Application No: AB/49/22/HH
Site Address: 31 Tarrant Wharf Arundel BN18 9NY
Description of works: Erection of single storey rear extension including the installation 2 x rear balconies and side rooflight and alterations to fenestration. This application may affect the character and appearance of the Arundel Conservation Area.

Thank you for your internet representation made on 22nd May 2022 which has been recorded as an objection with the comments as follows:

DRAWING TITLE
 PROPOSED FLOOR PLANS,
 SECTION AND ELEVATIONS

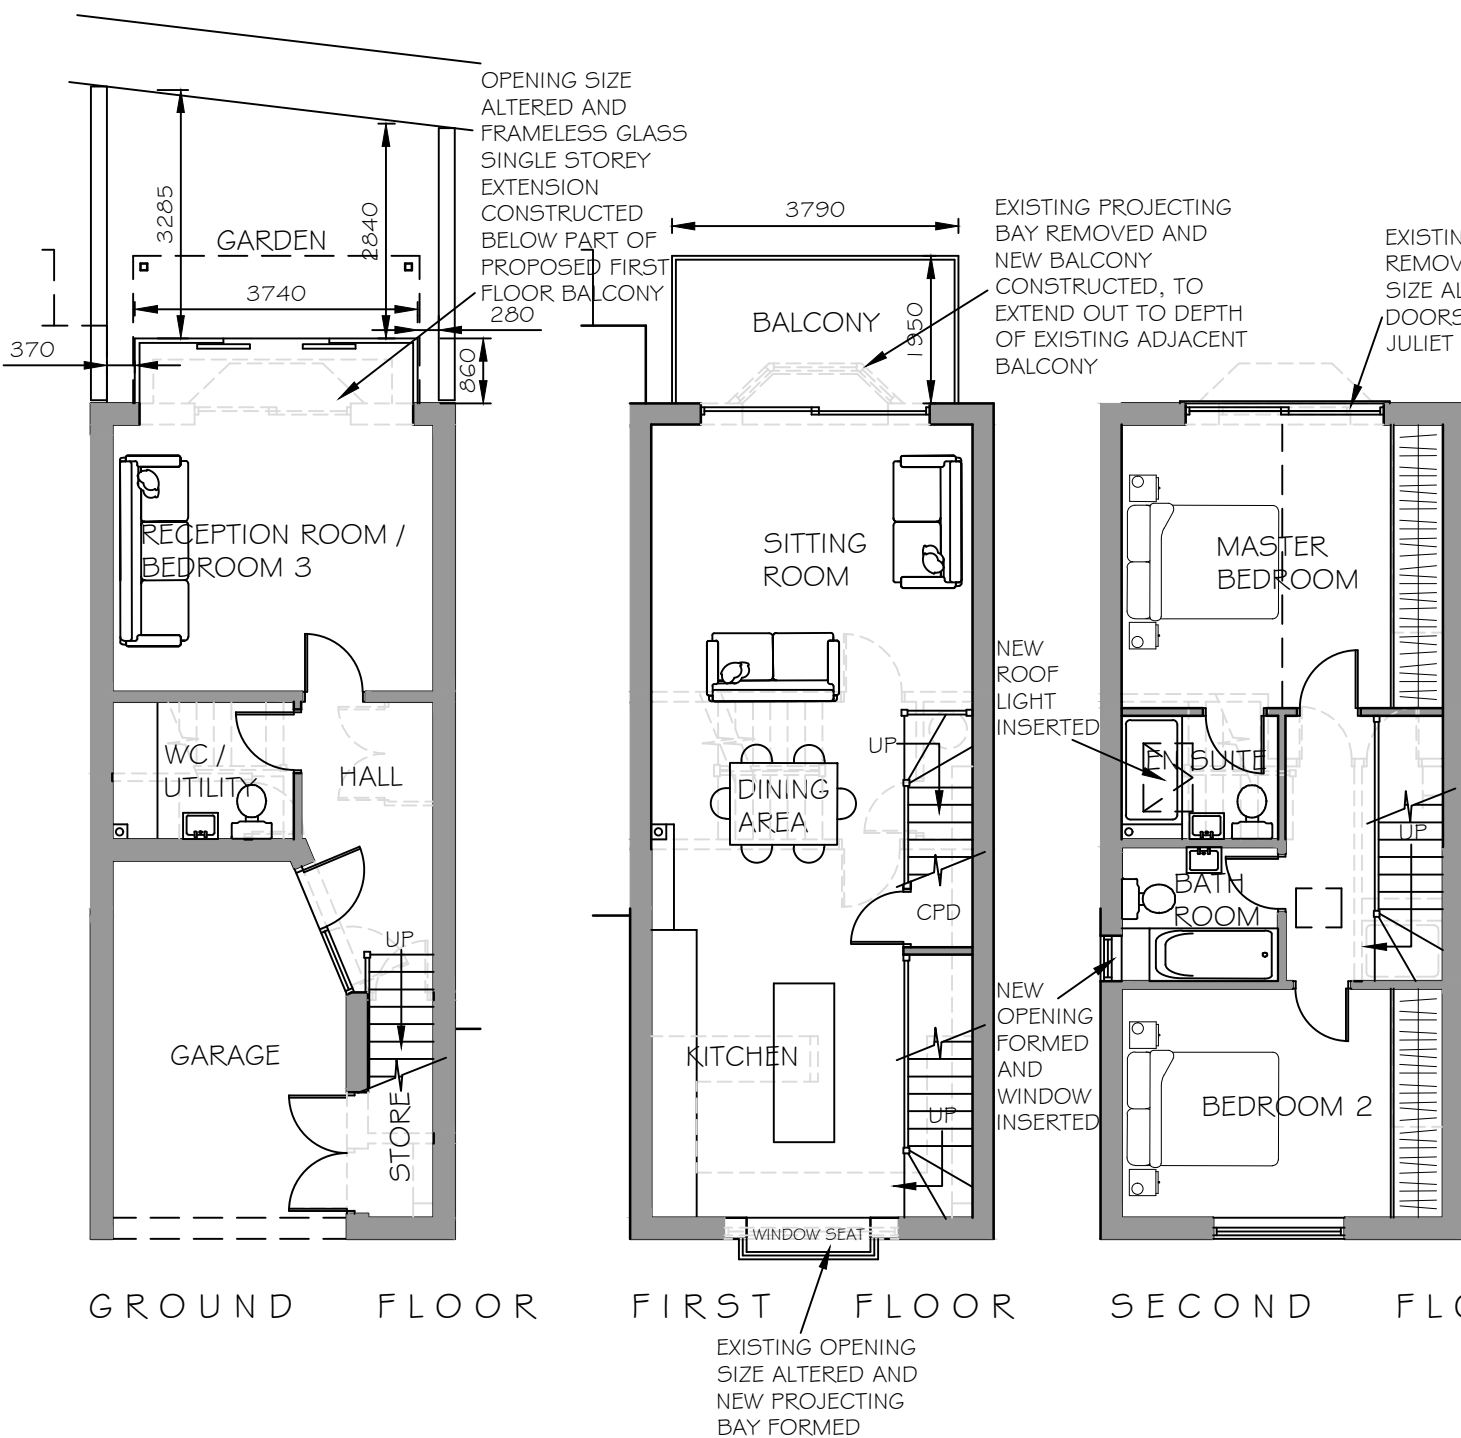
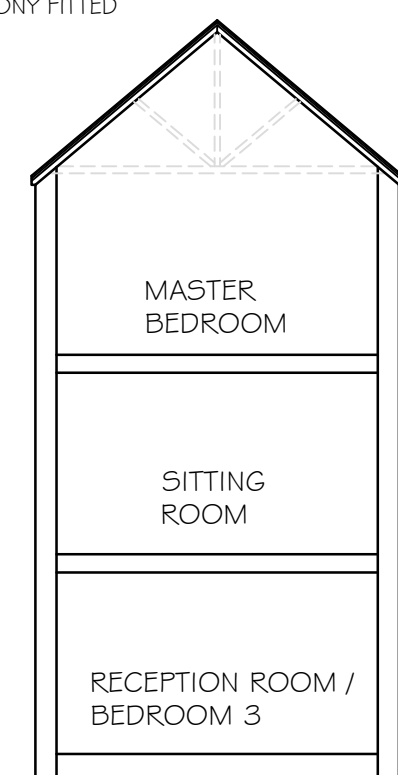
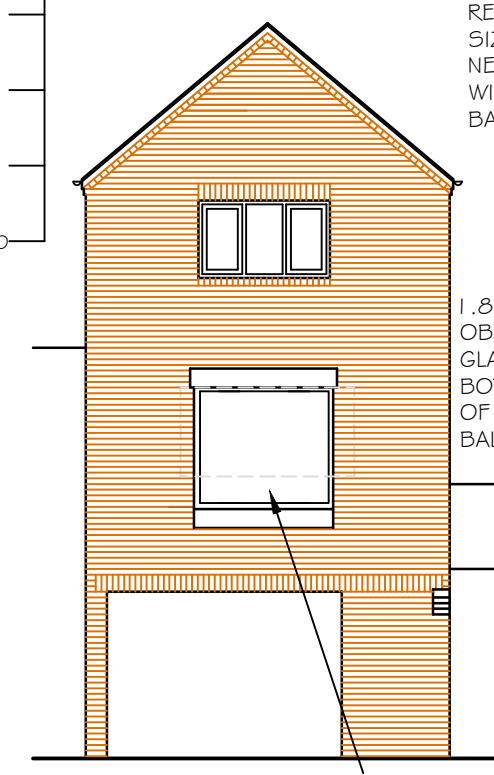
The proposed drawing plans are inaccurate. The rear elevations of no29 and 31 Tarrant Wharf are not in a straight line but are at an angle of approx 170 deg to each other, as are the houses. Therefore the proposed rear room and balcony extensions will reduce the building/boundary gap to zero as they extend into the garden given the building gaps proposed.
